Our ref: Newington College Redevelopment (Concept and Stage 1) (SSD-78268465)

Subject: Response to Submissions

I refer to the State Significant development application for the Newington College Redevelopment (Concept and Stage 1) (SSD-78268465) and the Department's Response to Submissions (RtS) letter dated 15 July 2026.

ATTACHMENT 1 KEY ISSUES / FURTHER INFORMATION REQUIRED

SHEET TITLE
STAGE 01 -
TEMPORARY CAR
PARK PLAN

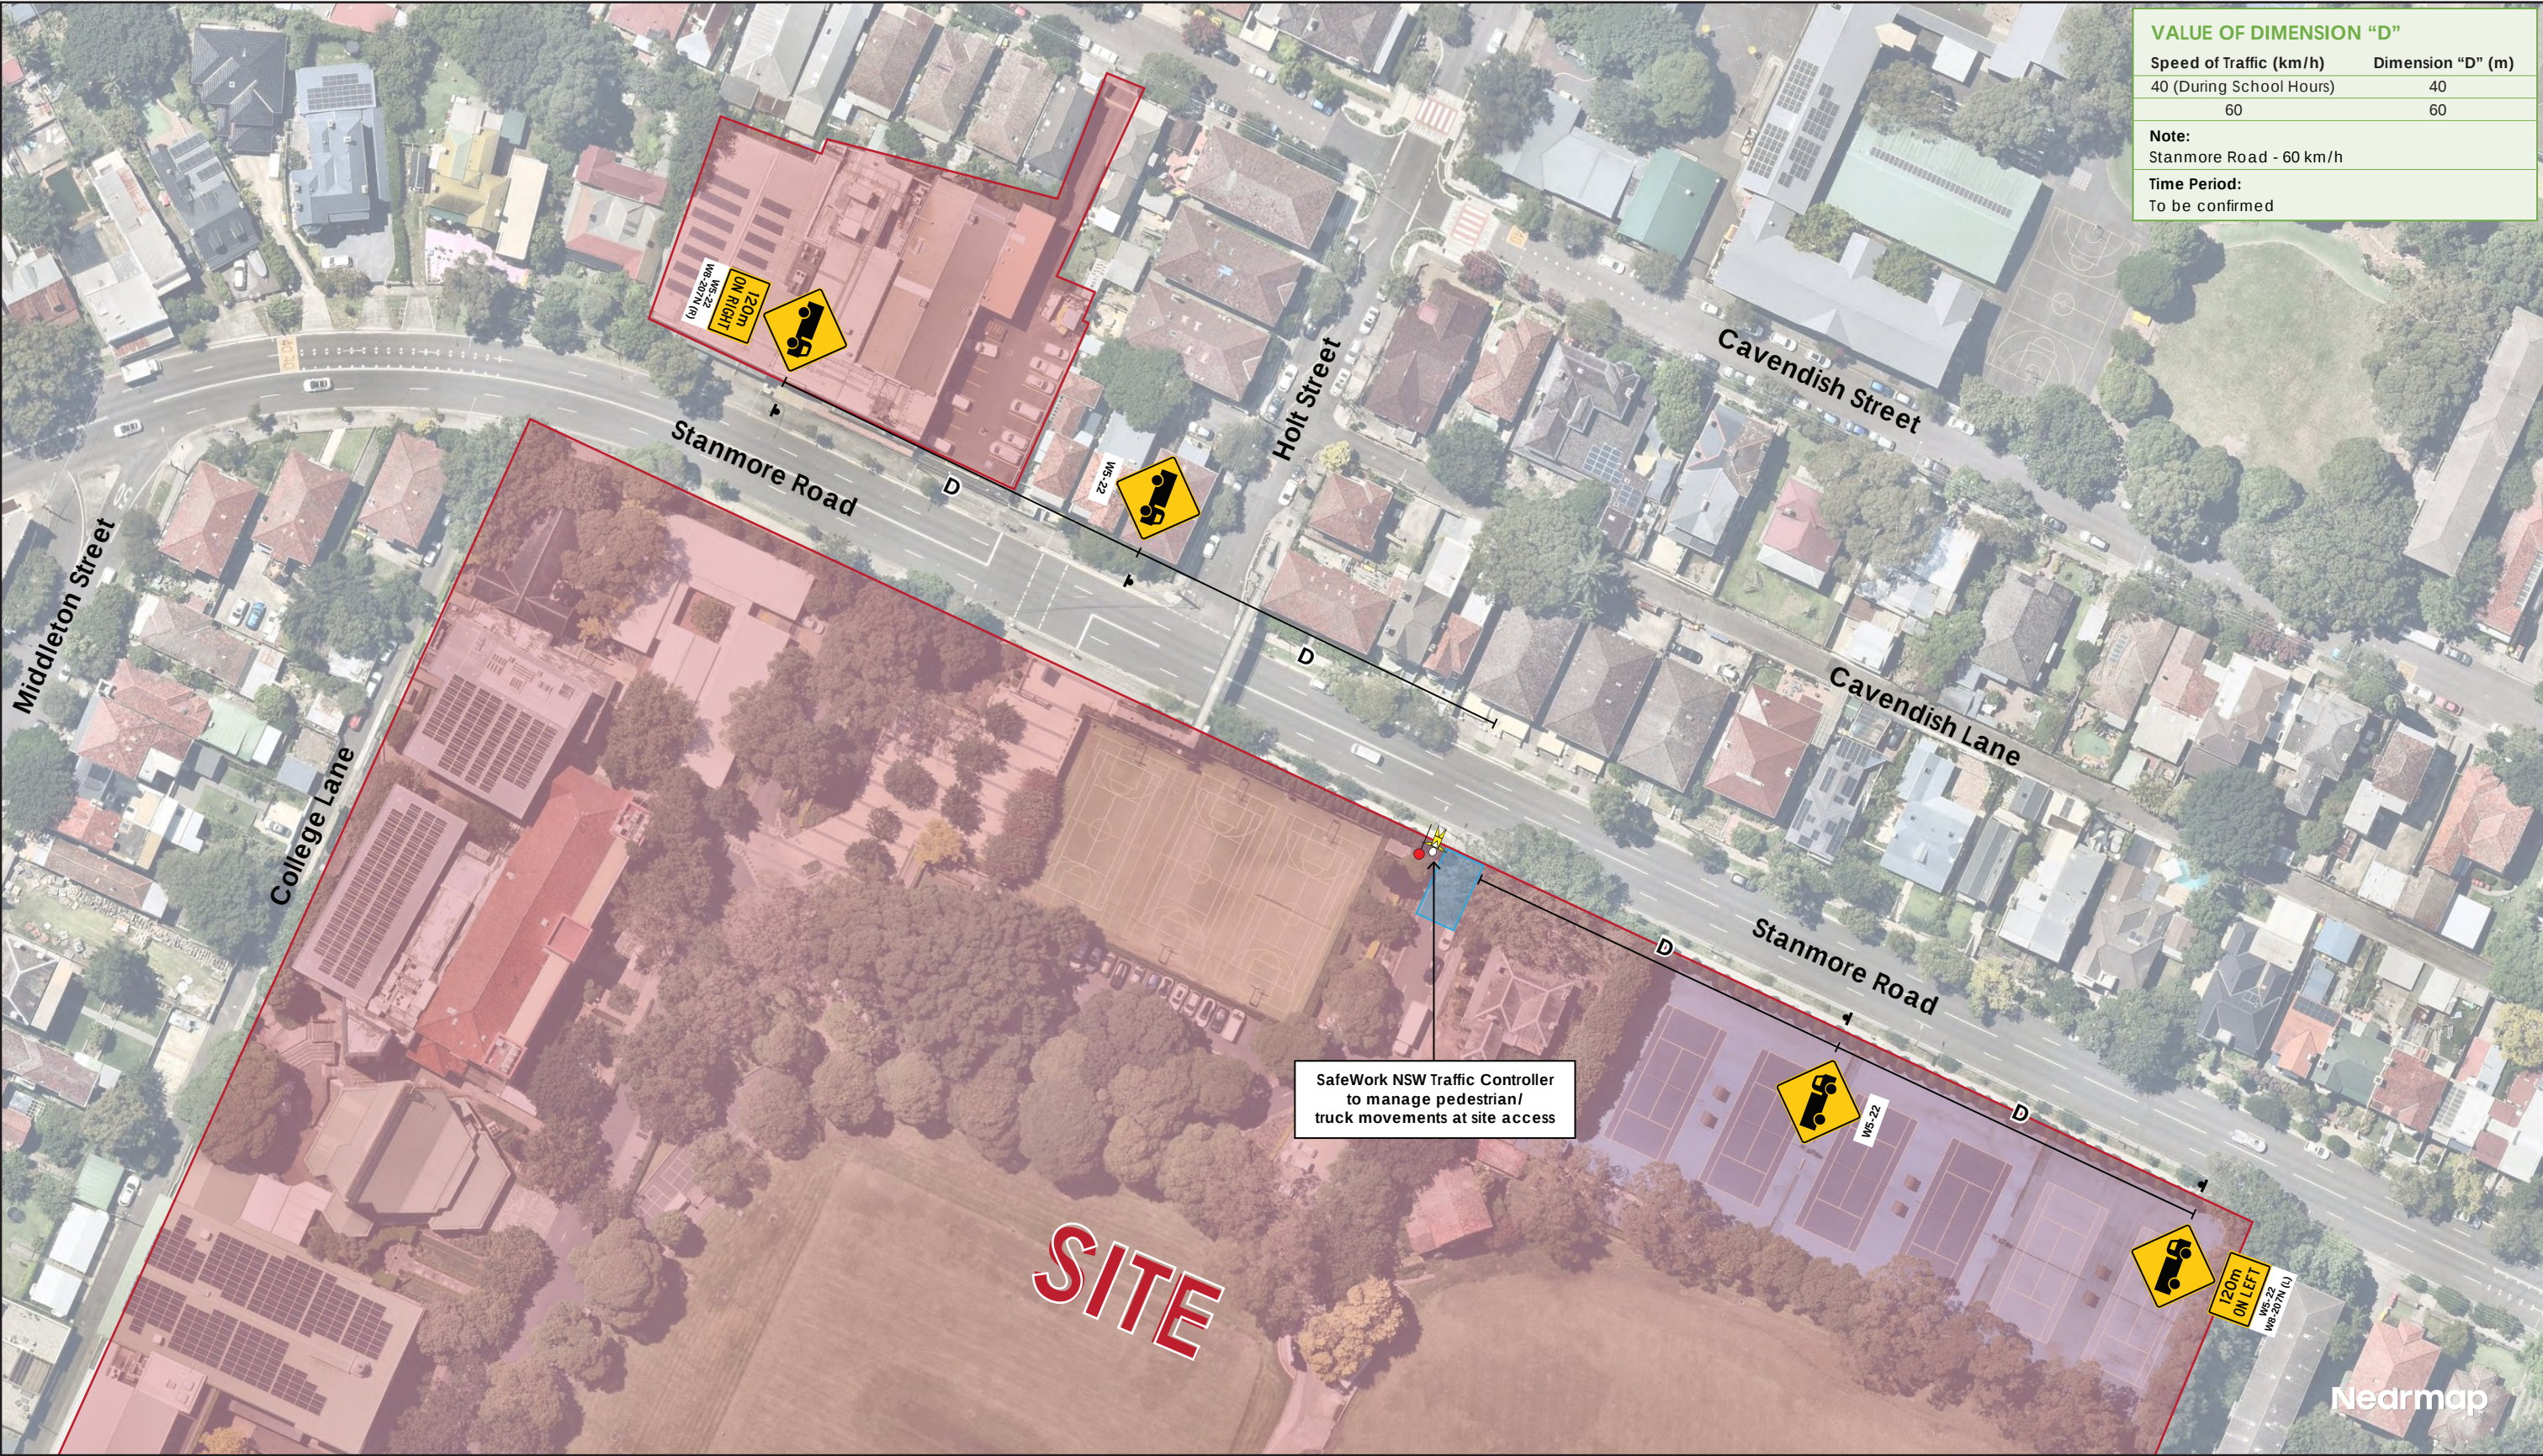
- Provide landscape plans demonstrating the reinstatement of the tennis courts, landscaping and associated works following the decommissioning of the temporary carpark.

North Facade - Stanmore Road

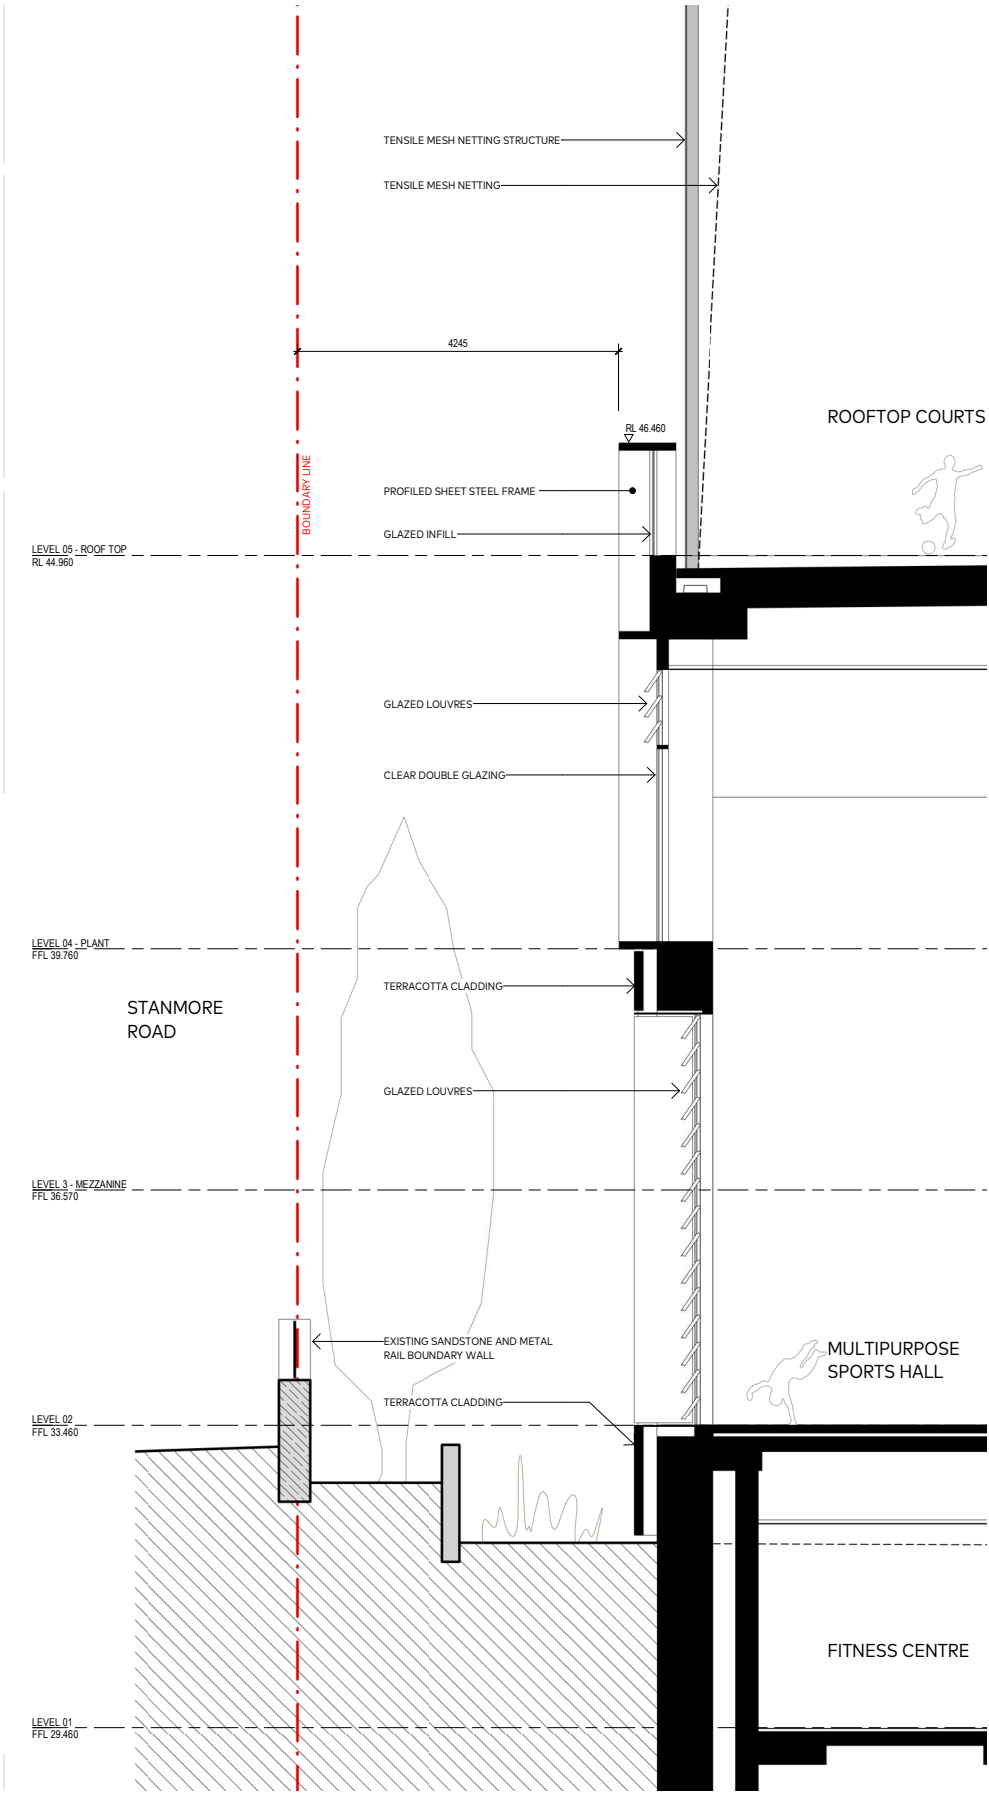
- With particular emphasis on the extensive Stanmore Road frontage and the eastern elevation of the Sevington Building, large areas of façade are visually inactive and lack articulation and detailing at a pedestrian scale. Further development of the material palette and façade detailing is required to:
 - provide further façade articulation and a more deliberate balance of solid and transparent elements to reduce the perception of a long and continuous built form
 - improved fine-grain presentation to Stanmore Road
 - establish a clearer hierarchy, differentiation and variation of façade elements to break down the overall building length and better respond to the finer grain of the streetscape
 - improve the integration of architectural and landscape design measures.
 - strengthen built form relationship with the surrounding streetscape character.

6.18 Building Signage

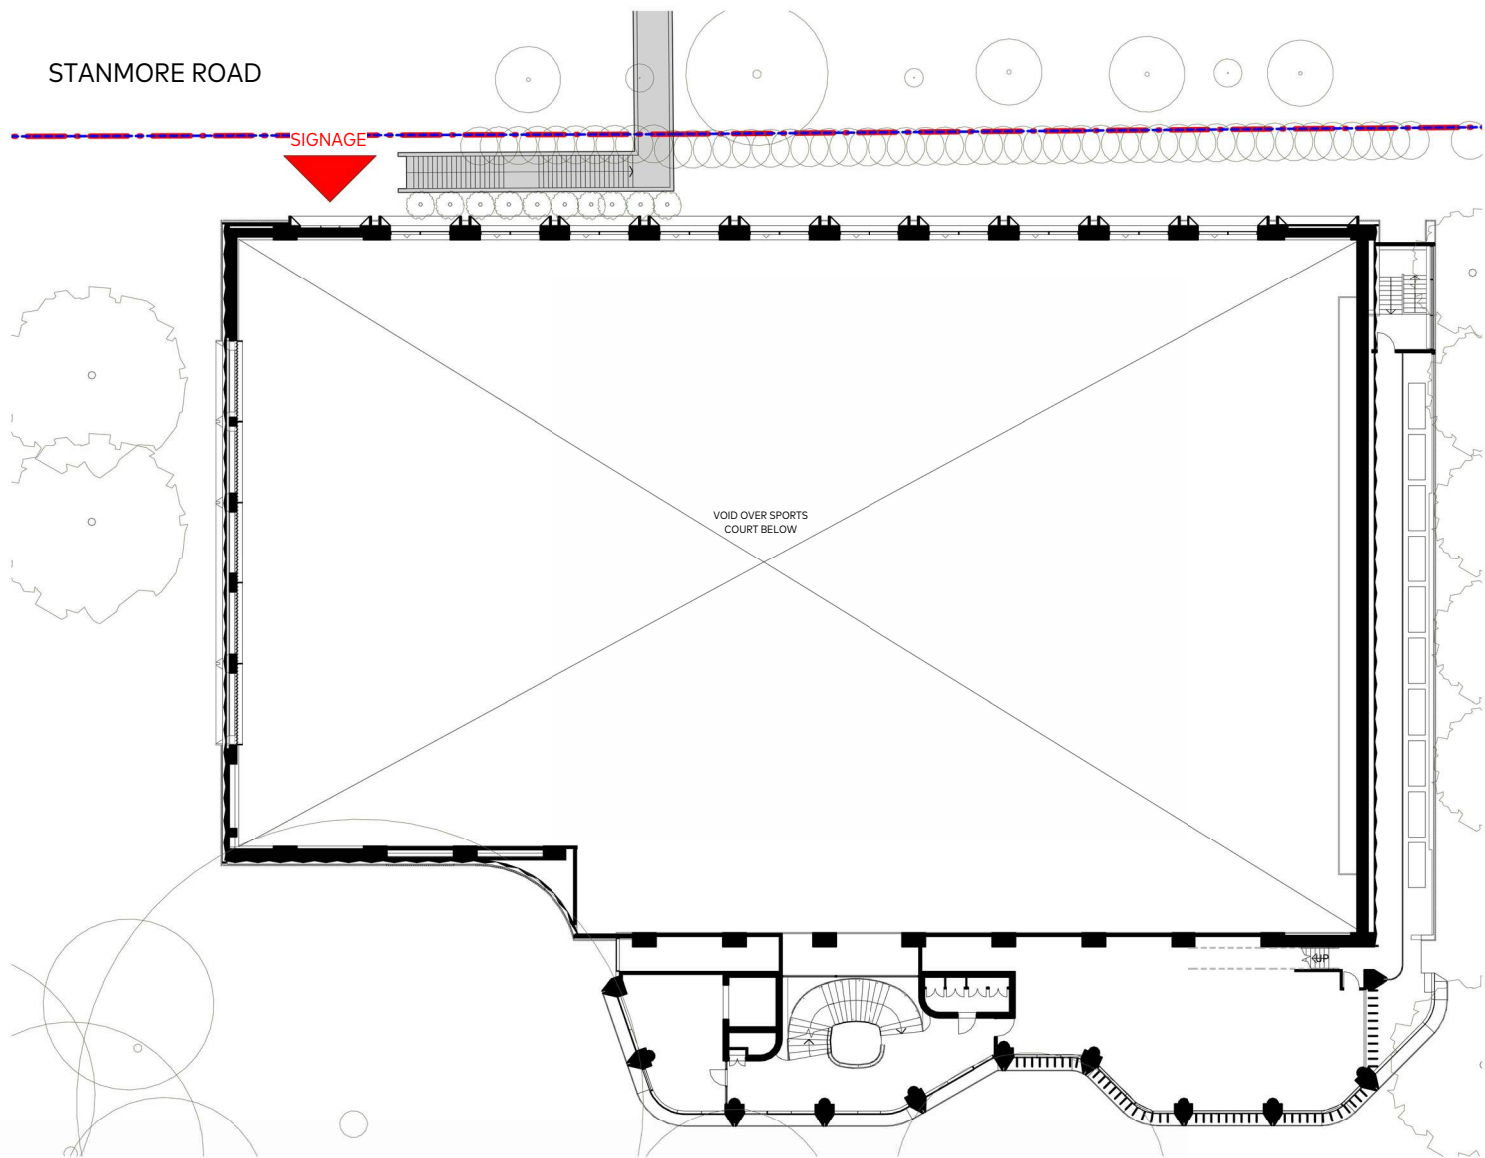
- Provide further details regarding the proposed illuminated signage along the Stanmore Road frontage, including luminance levels, hours of operation, any curfew arrangements and compliance with relevant standards and guidelines. The lighting advice note should assess the impacts associated with the proposed illuminated business identification signage.
